**Subject: Comments for Design Review Board on
January 13, 2021
Albuquerque, Bernalillo County, District Three**

Project Number: PR-2020-004604

Case Description: Site Plan

Location: Holly Ave @ Ventura

**A1.10**  
PRELIMINARY SITE PLAN

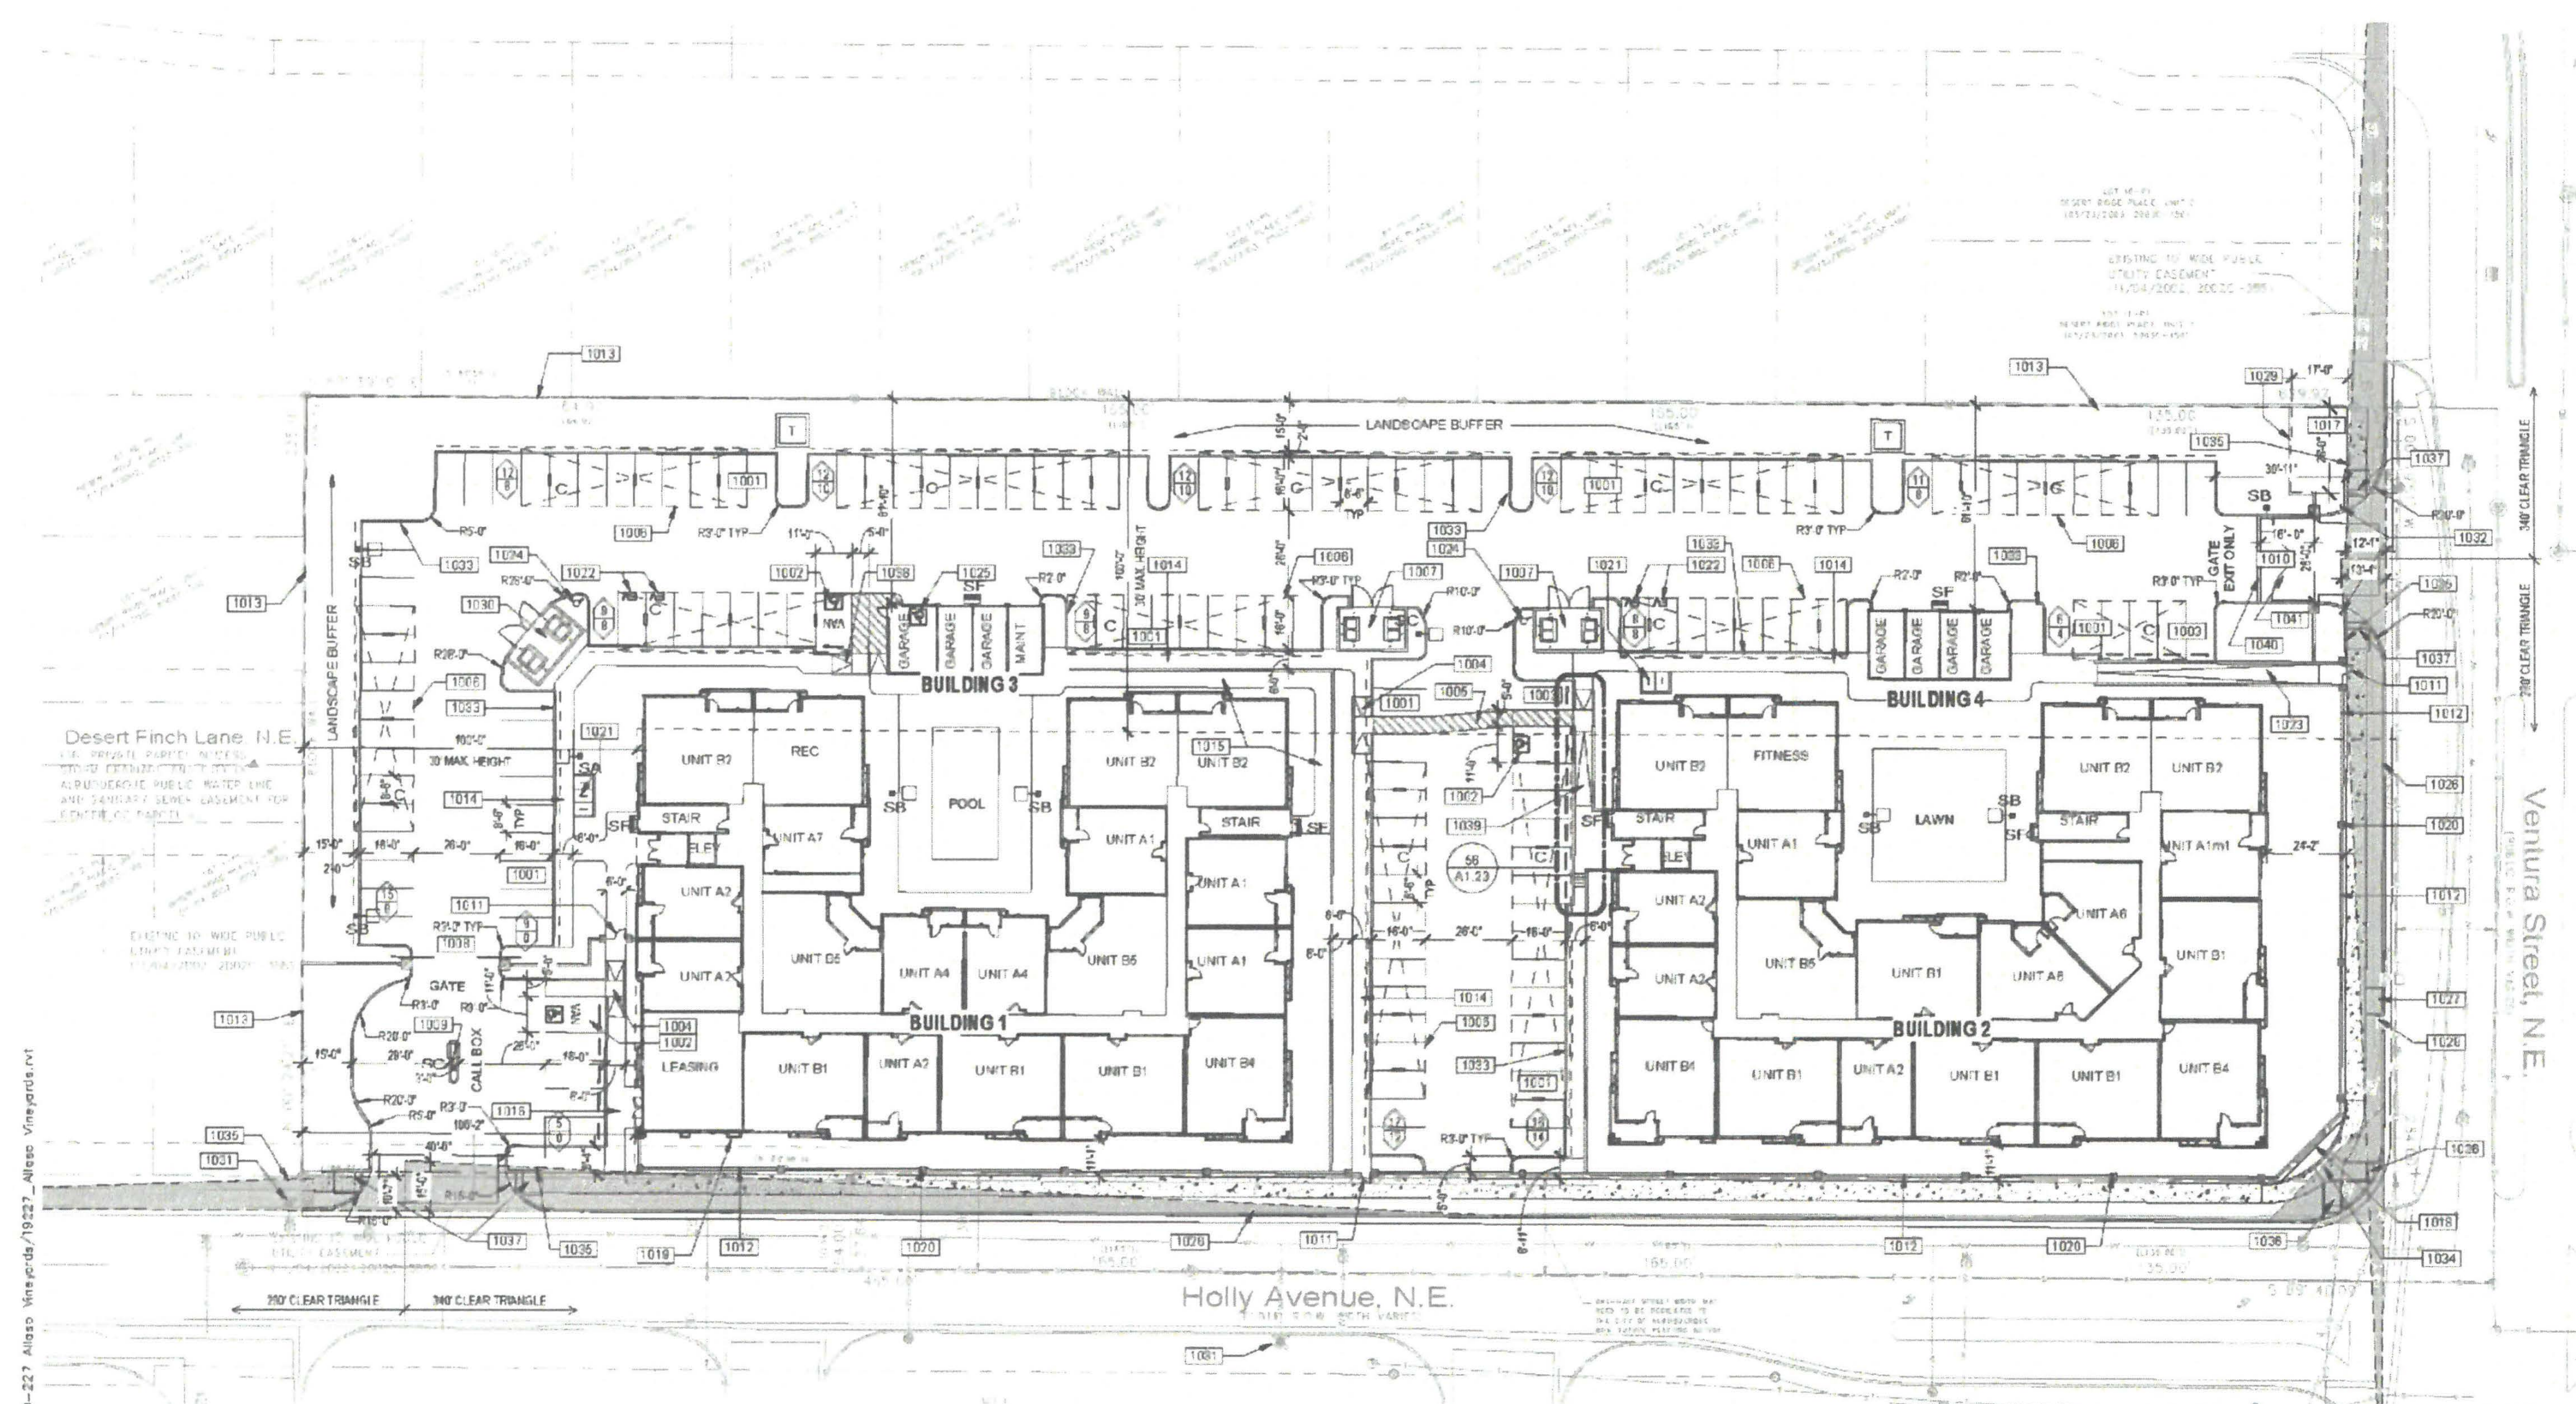
- NMDOT is requiring the TIA be provided to Assistant Traffic Engineer Margaret Haynes for review and concurrence due to the proximity to NM 423. Mrs. Haynes can be reached at Margaret.haynes@state.nm.us or 505-288-2086. In addition TIA review the following shall be included but not limited to sidewalk extension along Ventura & Holly, Median Bull Noses shall be painted Yellow with RPMs within Ventura, SB Ventura Right Deceleration Lane at NM 423 to be evaluated for extension.
